Oxford Works, 4650 Cascade Way, OX4 2SU

**PRE-APP 03 - JANUARY 2024**

ILLUSTRATIVE VIEW - Rear elevation

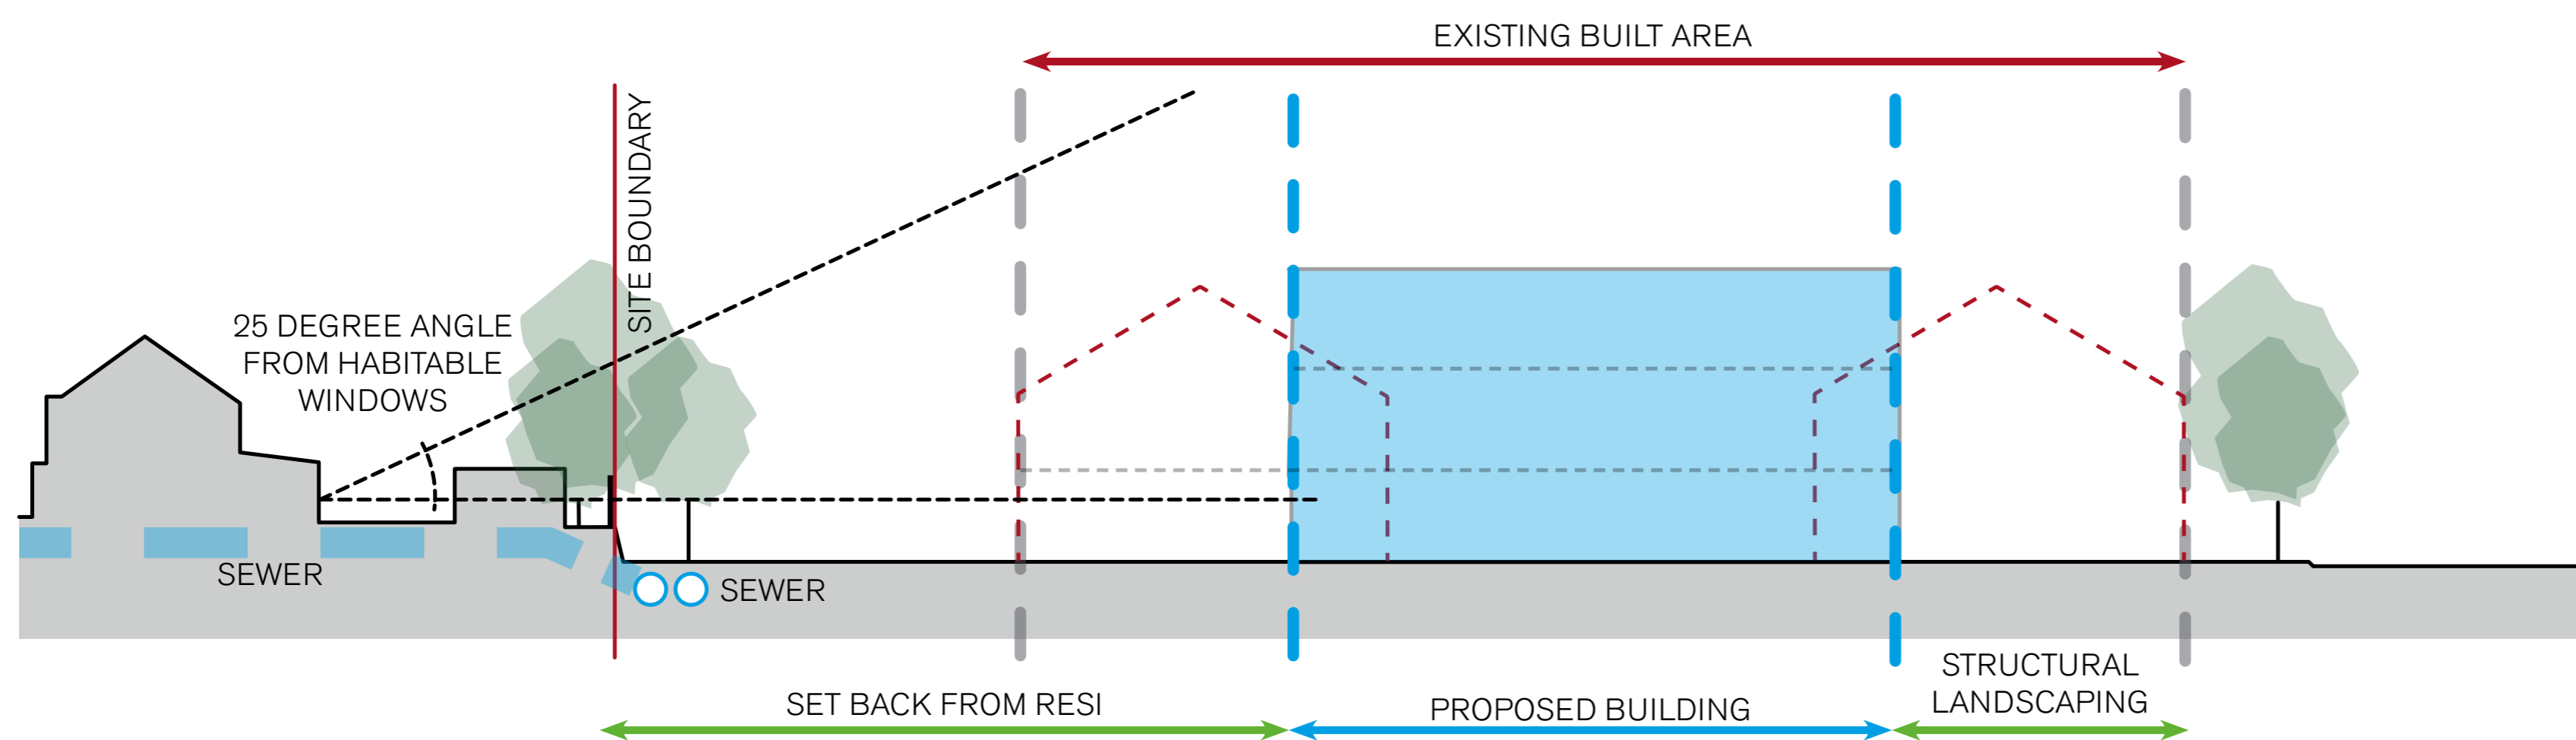
- ... the change in materiality and simplification of the fenestration is positive, however the building remains overbearing in its scale, height and mass when experienced from residential dwellings on Bailey, Frederick and Phipps Roads.

- I suggested that the building is stepped down to achieve more successful articulation.

- North and South wings are moved 5.4m further away from nearby residential properties.
- The Second floor is set back a further 1.1 m, an increased distance of 6.5m when compared with Pre-App 02.
- Central bay and rear entrance are moved over 2m away from residential properties.
- Plant screen set back 2.6m away from residential properties and partially relocated to the front of the building.
- Fenestration has been revised for typical windows to include a central mullion / fin which breaks down the size of glazing and obscures overlooking from oblique views.
- Additional landscaping is proposed between the building and the rear plot boundary, including more trees to provide further screening.

- The combination of the second floor set back combined with switching the one third/two third principle of the floors successfully articulates the rear elevation and connects the buildings elevations together from front to back.
